REZONE MAP

TRACTS A-1, A-2, A-3 AND TRACT C SETTLERS RANCH SUBDIVISION FILING NO. 2C, LOCATED IN A PORTION OF THE S1/2 OF THE SE1/4 OF THE NE1/4 & A PORTION OF THE S1/2 OF SECTION 23, & THE SW1/4 OF THE NW1/4 OF SECTION 24, TOWNSHIP 11 SOUTH, RANGE 66 WEST OF THE 6th P.M., EL PASO COUNTY, COLORADO

REZONE TRACTS A-1, A-2, A-3 & C SETTLERS RANCH SUB. FILING NO. 2C PT. SEC. 23 & 24, T11S, R66W, EL PASO CO., CO

V1_Zoning Map redlines.pdf Markup Summary 12-6-2022

REZONE MAP

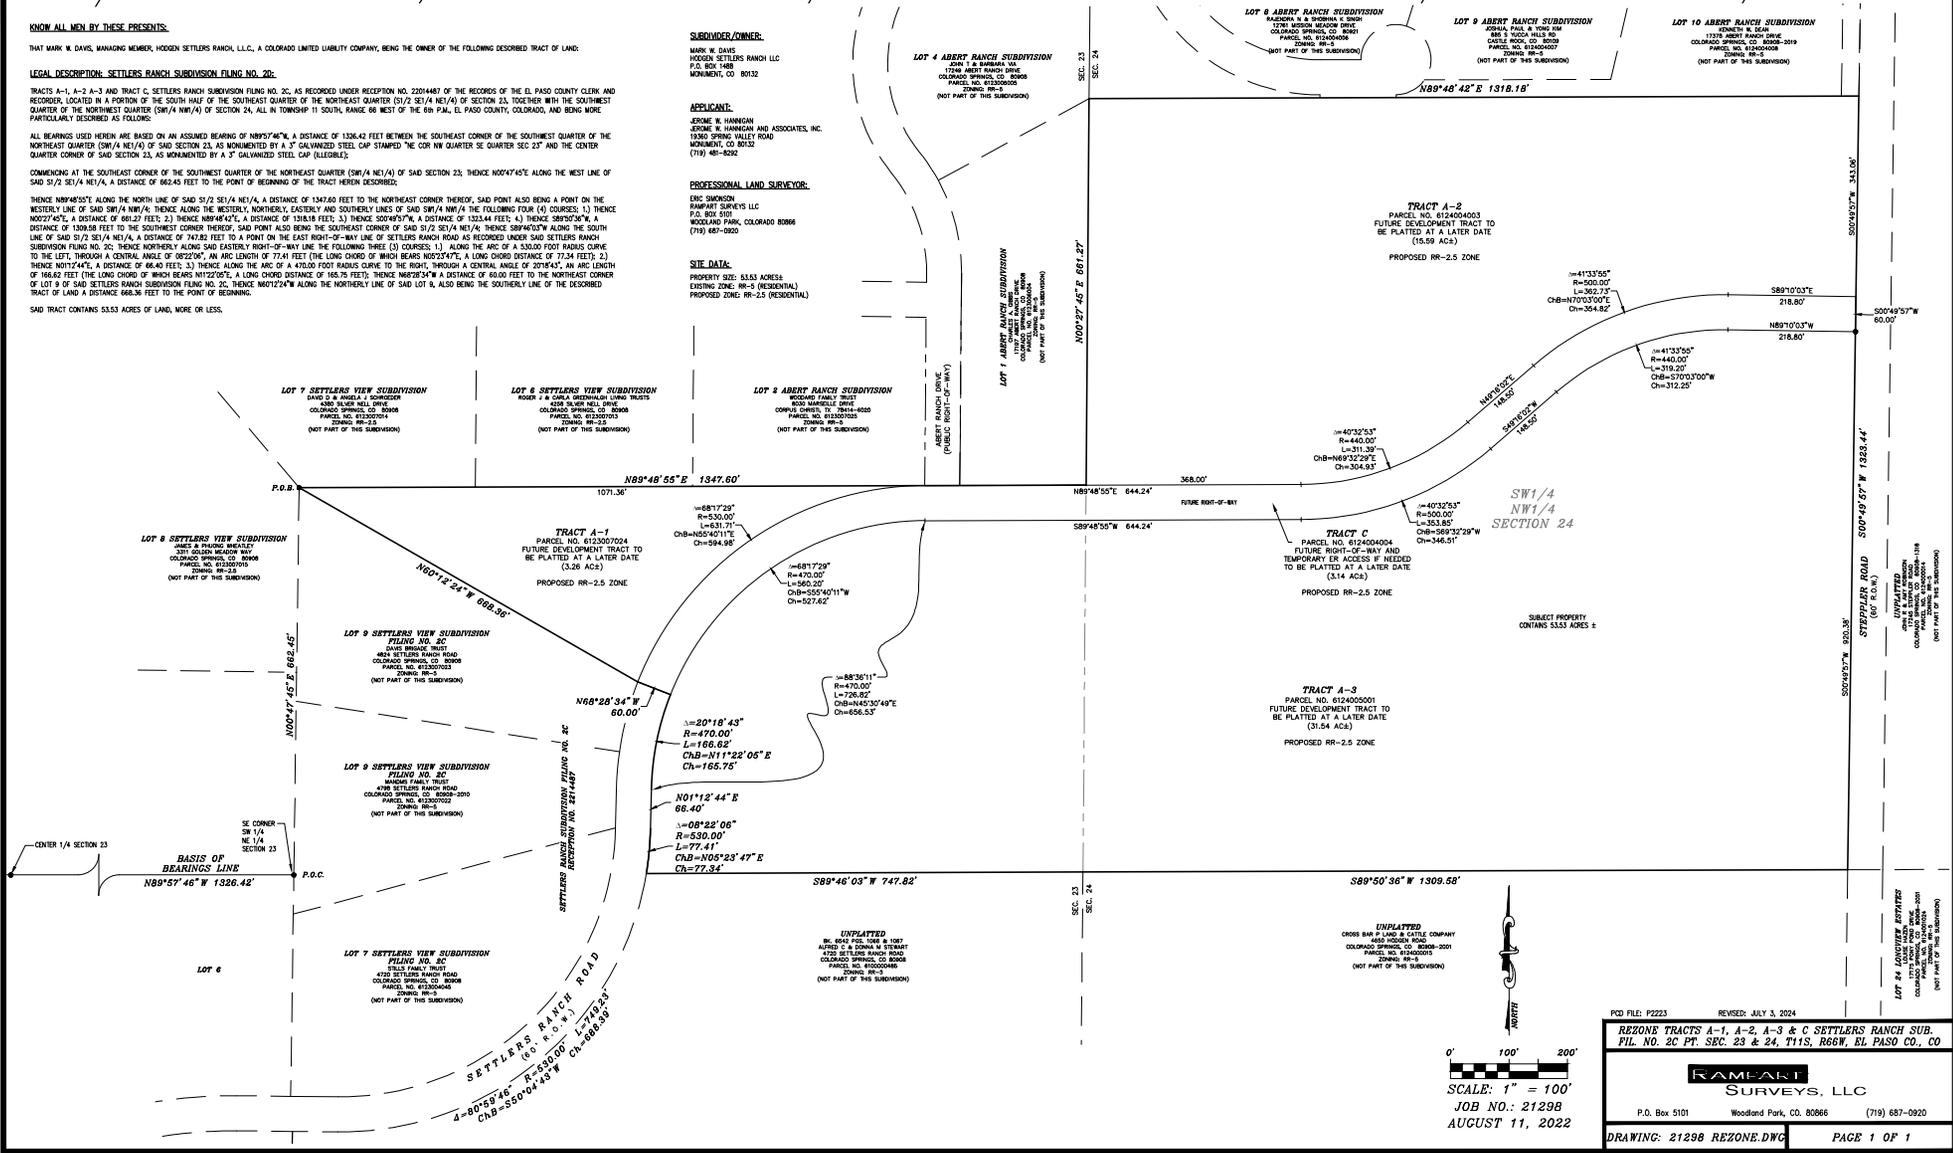
label proposed RR-2.5 zone

label proposed RR-2.5 zone

label proposed RR-2.5 zone

label proposed RR-2.5 zone

is this not accurate? i though road is open...please correct old notes or remove.

public ROW

is this still a valid note? remove if not valid
